City of Albuquerque

**RE: FedEx Ground ABQ Drainage Report and Grading Plan and Drainage Plan
Engineer's Stamp Date 8-12-14 (K09D026A)**

Per correspondence from your office dated September 2, 2014, please find the following responses addressing the drainage comments listed below:

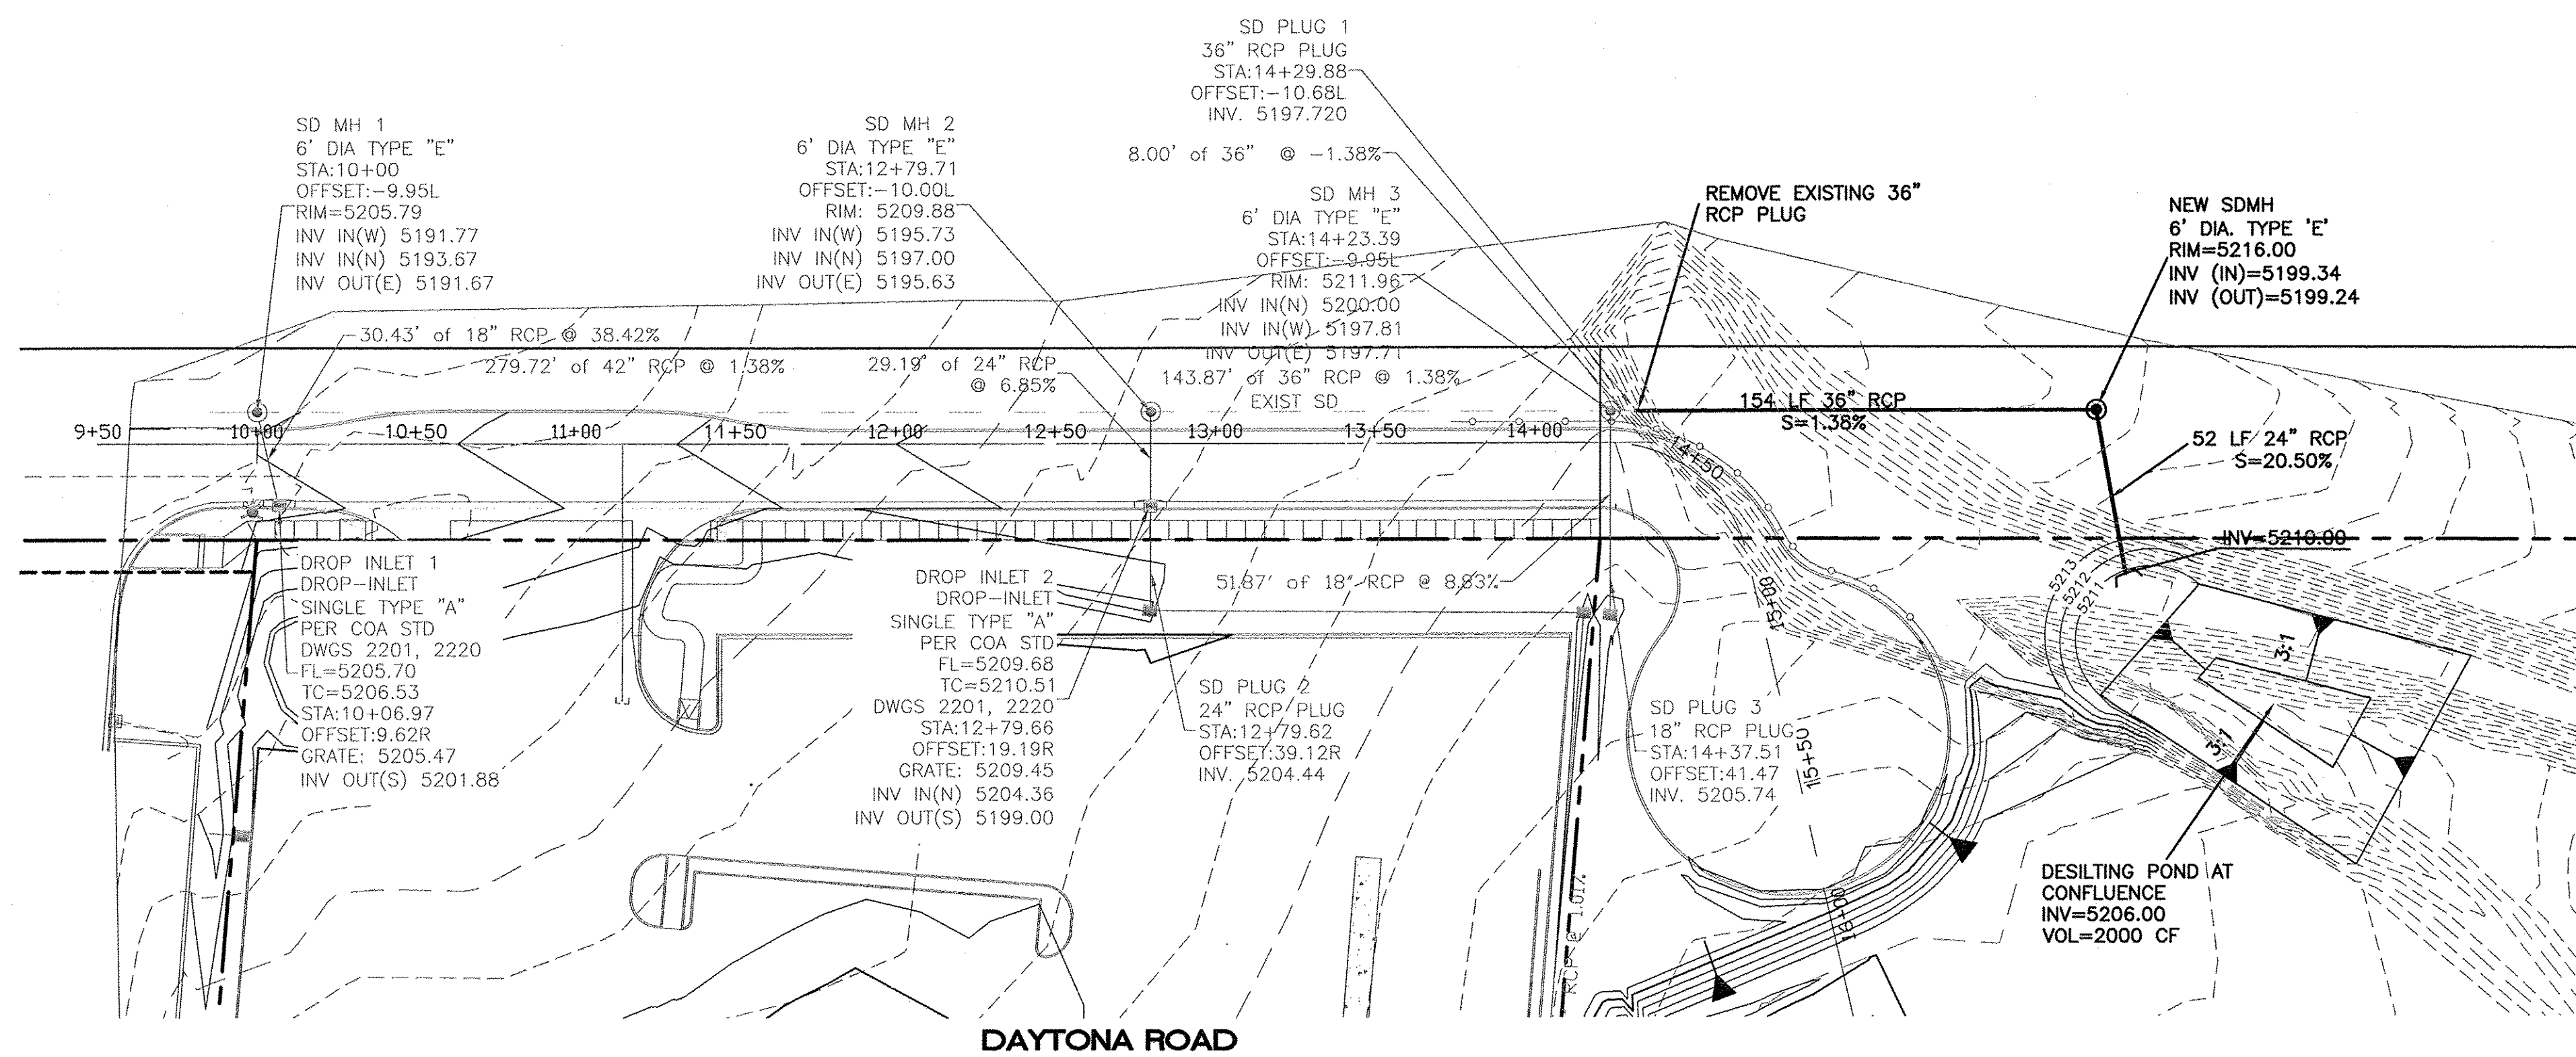
1. Provide contours for the western portion of the Pre and Post Developed Drainage Basin Maps. Show the current layout of the Daytona ROW going through the western basins on the Basin Map. Show the desilting pond and storm drain west of Daytona Road on the Post Developed Drainage Basin Map. West of Daytona, construct desilting pond slopes outside of the ROW and extend the proposed storm drain as necessary. Provide the updated Daytona Road Grading and Drainage Improvements sheet, GR-6, which was submitted with the previous submittal but not this one.

Response: The basin maps have been updated with the requested information. The Daytona Road grading and drainage improvements sheet is included.
